Project# 1010280

15DRB-70041 MINOR - PRELIMINARY/ FINAL PLAT APPROVAL

PROJECT NAME: Tract(s) 268 B1 & 268A1A

**CITY OF ALBUQUERQUE
PLANNING DEPARTMENT
February 11, 2015
DRB Comments**

SIDEWALK AND PROPOSED EASEMENT EXHIBIT
OF
LOTS 1-5
LAUDENTE MONTOYA SUBDIVISION
BEING A REPLAT OF
TRACTS 268B1 & 268A1A M.R.G.C.D. MAP NO. 38
PROJECTED SECTION 18, T 10N, R 3E, N.M.P.M.
TOWN OF ALBUQUERQUE GRANT
ALBUQUERQUE, NEW MEXICO
JANUARY 2015

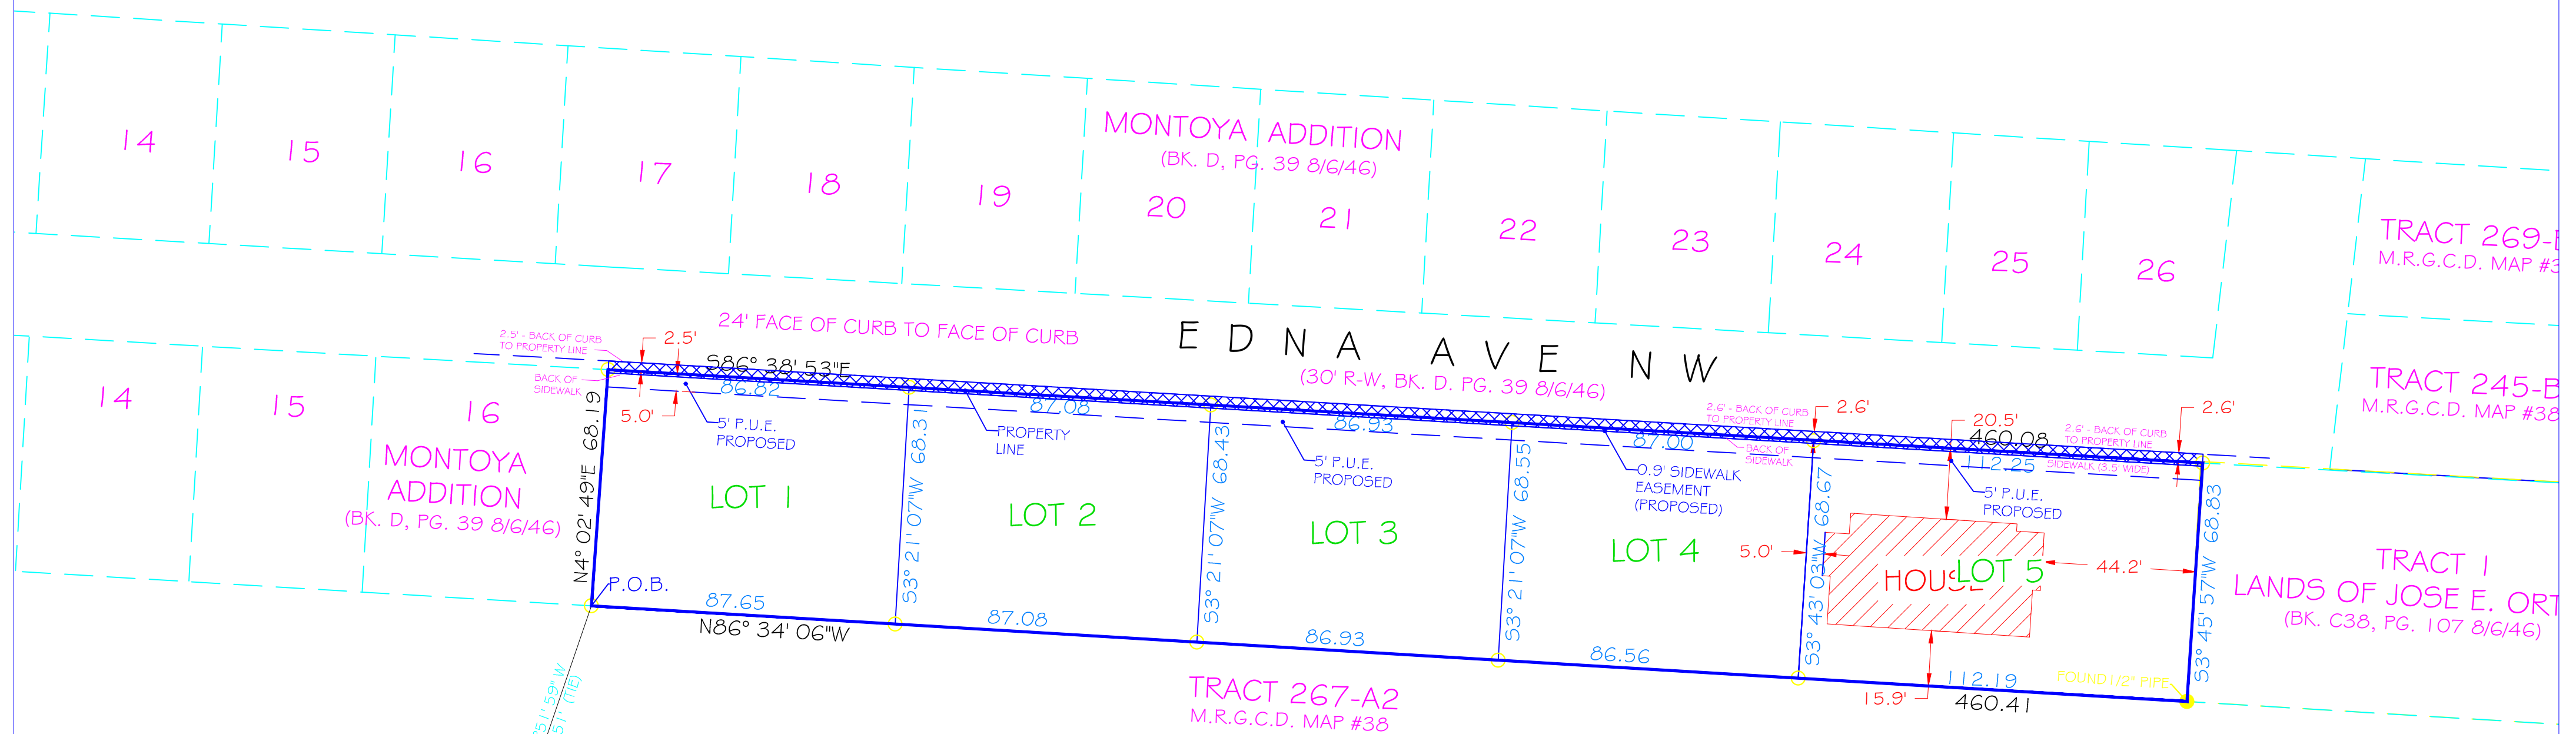
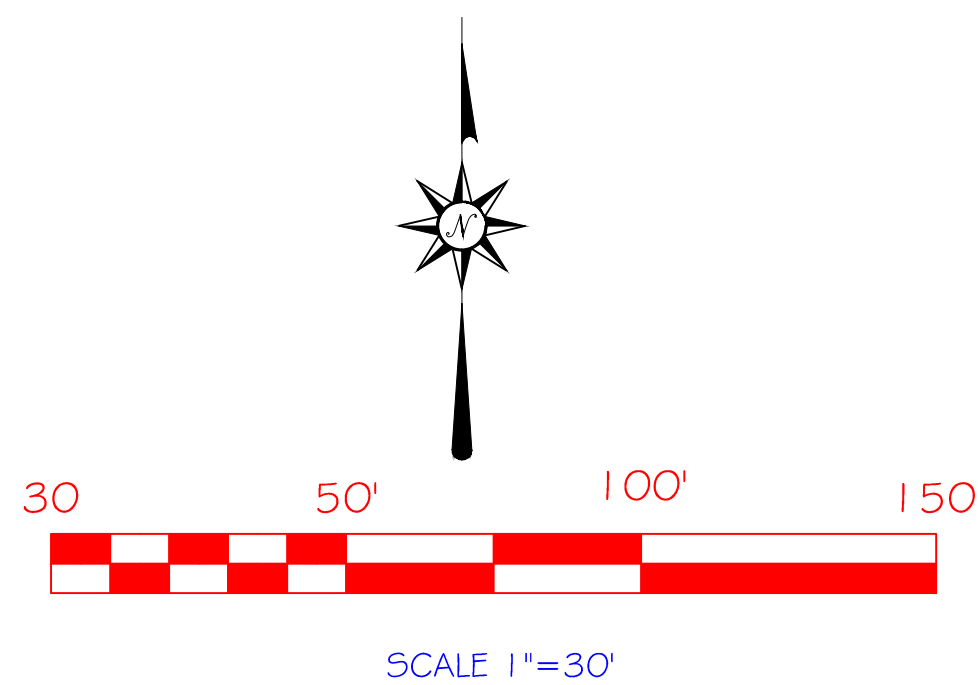
Planning: Element and construction of sidewalk around 2 utility poles with signature, copy

Refer to comments from Transportation Development regarding proposed Design Variances; based on existing utility poles in sidewalk, it appears additional sidewalk easement will be needed. An Infrastructure List may be required for additional sidewalk; the Sidewalk Easement should be labeled as PUBLIC.

JANUARY 2015

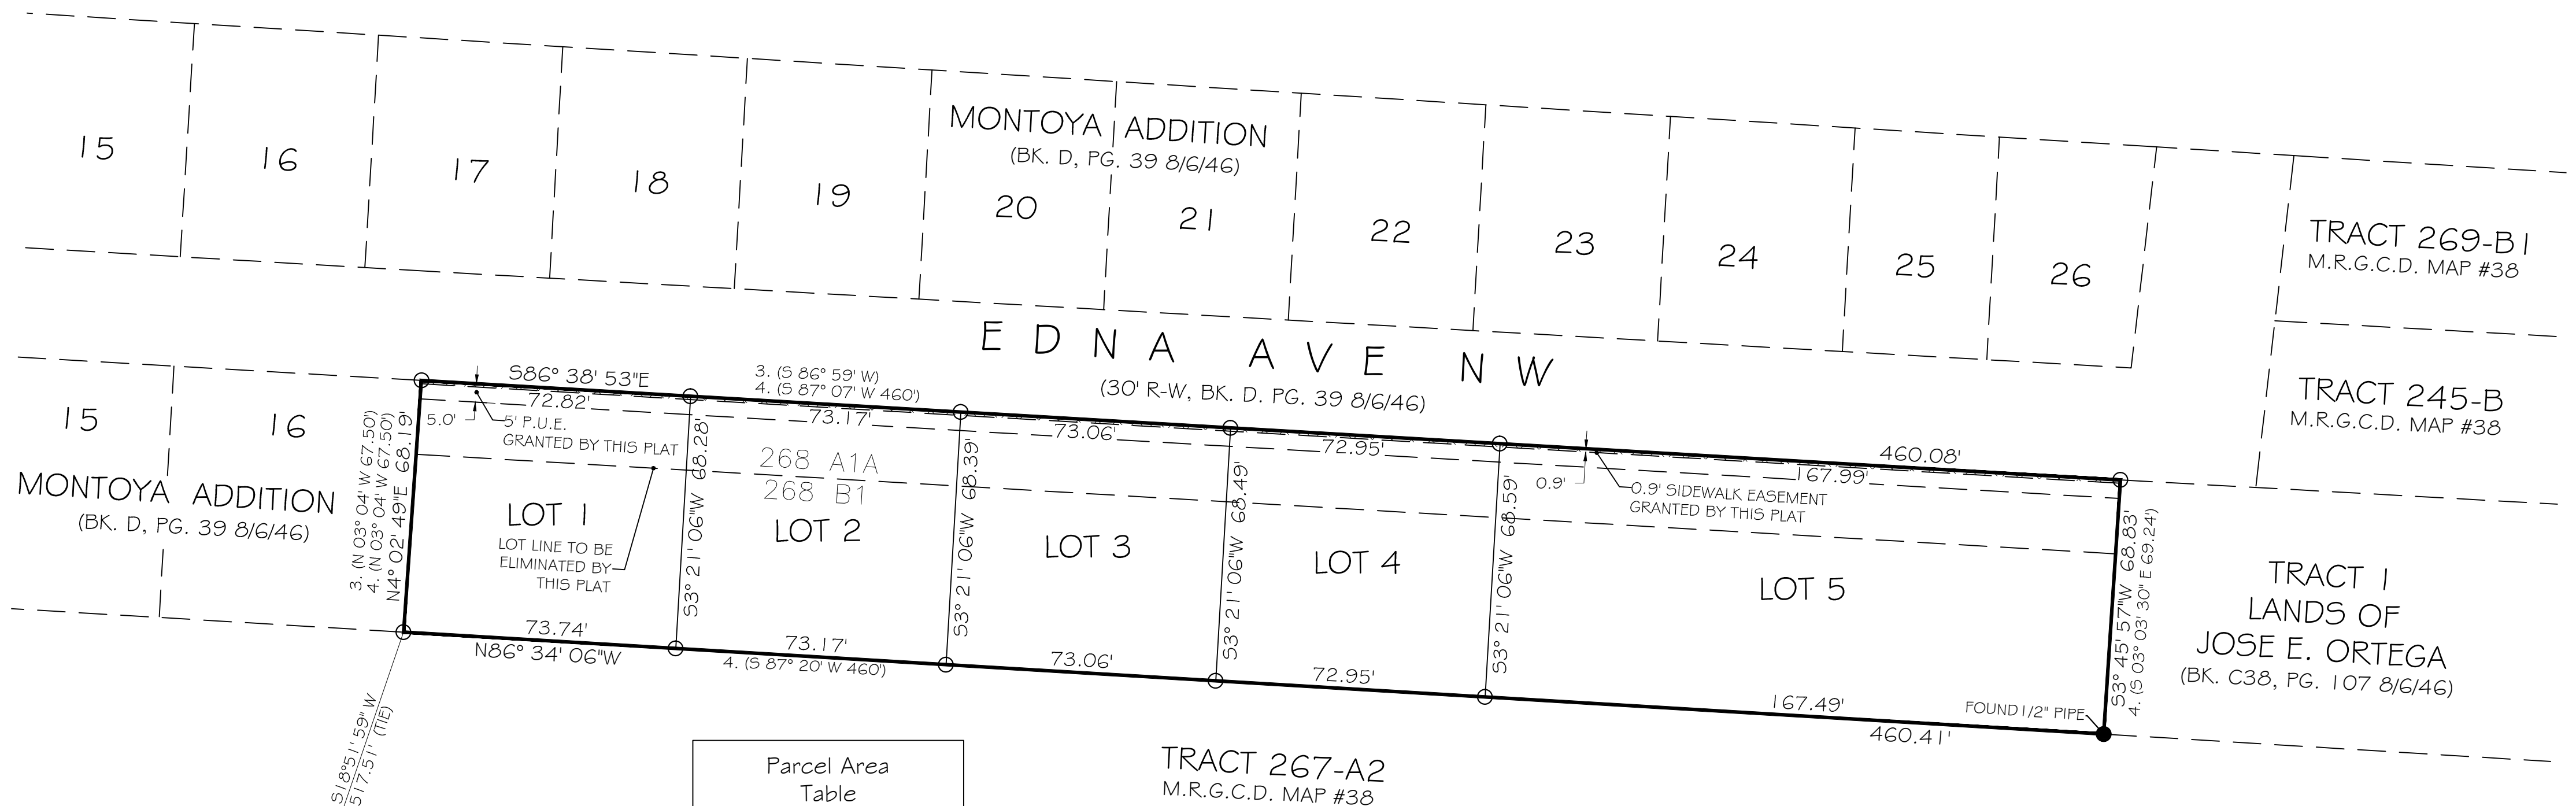
The proposed lots are much narrower than submitted for Sketch Plat – a site plan is needed for each proposed vacant lot to demonstrate that the lots are buildable while conforming to R-1 setbacks.
